From: Mau, Russell E (DOH) <Russell.Mau@DOH.WA.GOV>
Sent: Tuesday, September 9, 2025 5:09 PM
To: Bradley Gasawski
Cc: Melissa Schumaier
Subject: RE: SE-25-00014 Shamkhi - Notice of Application

The Department of Health (DOH) Office of Drinking Water (ODW) has reviewed the application generating the following official comments:

HOLIDAY HILL PRELIMINARY DESIGN
MUNIR SHAMKHI
PRELIMINARY WATER PLAN & PROFILE

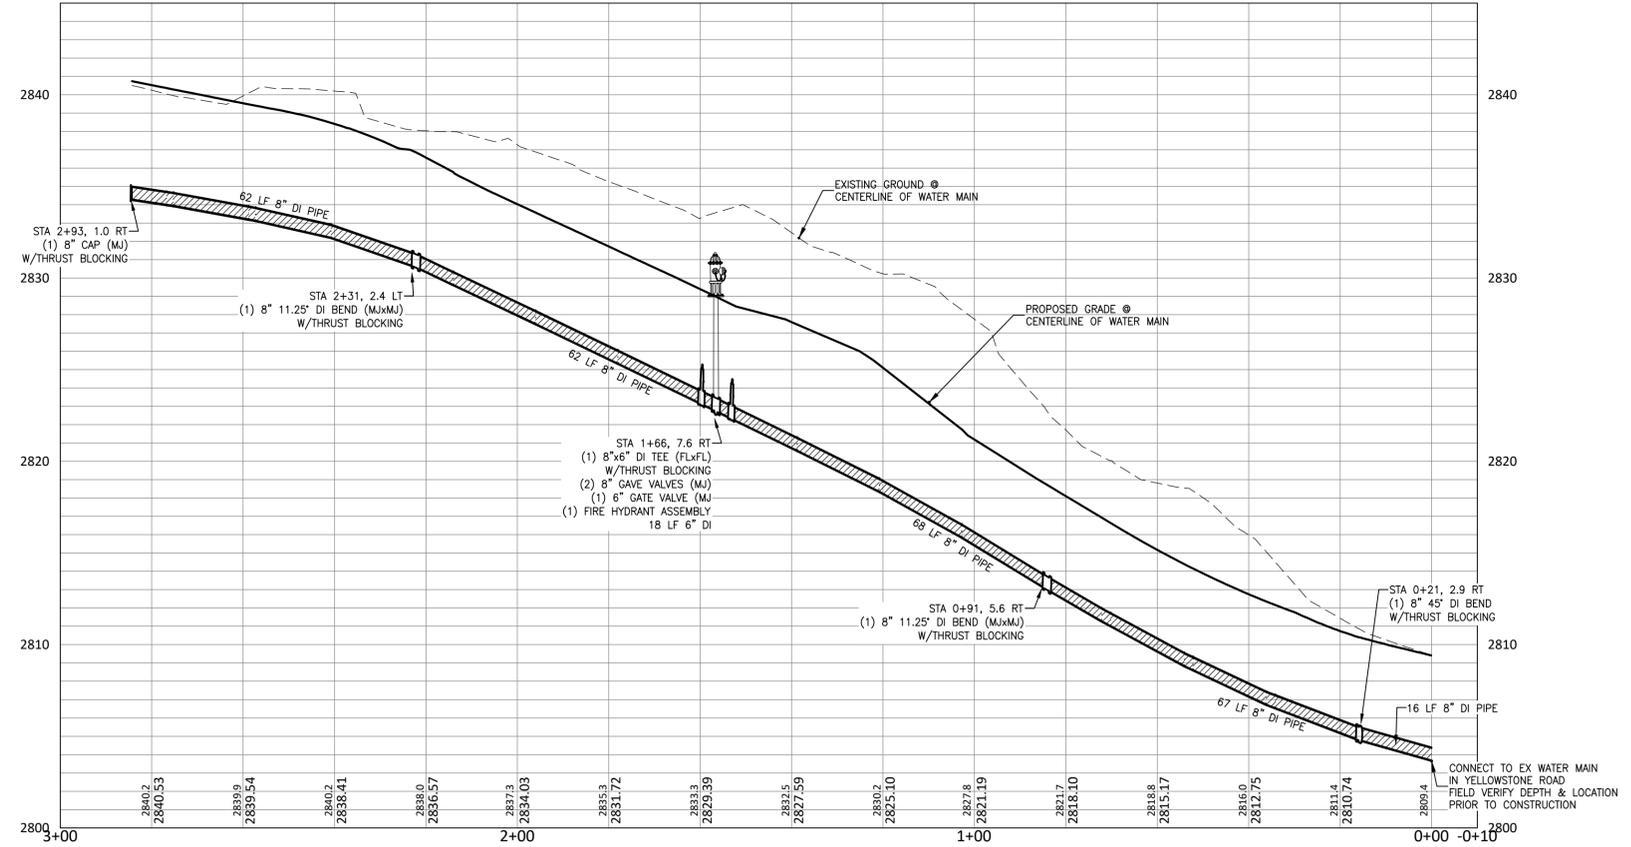
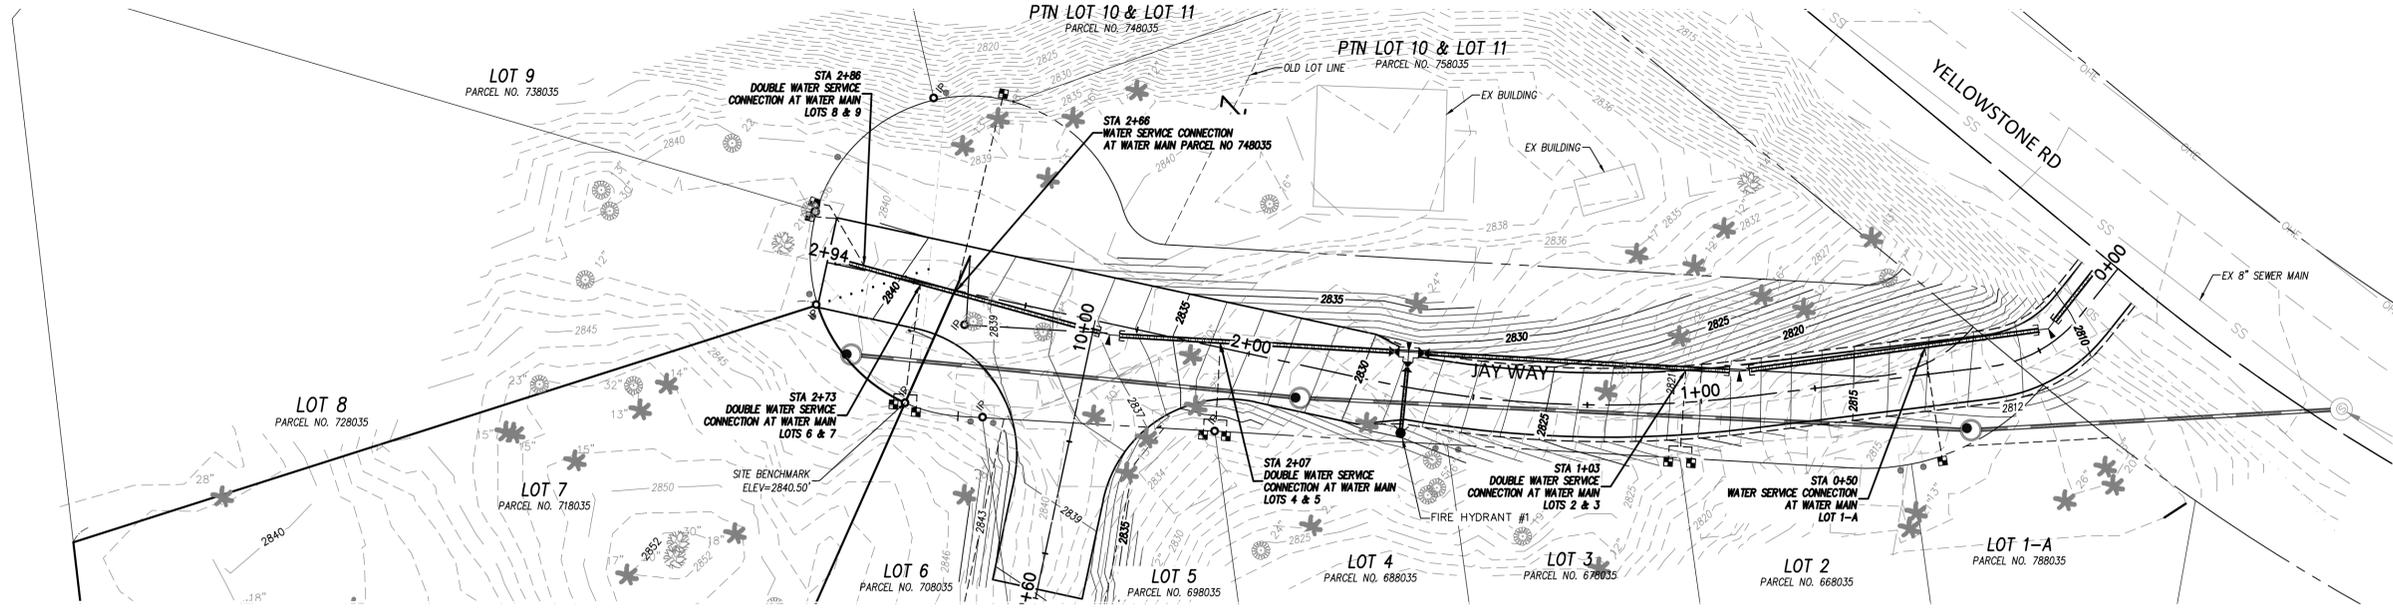
1. Is the applicant's property served by a public water system? DOH sees reference to both "West Water" (a now inactive public water system because of consolidation into another public water system) and Snoqualmie Pass water system that is an active water system.
2. DOH ODW will have additional comments if the response to the above comment is "yes".
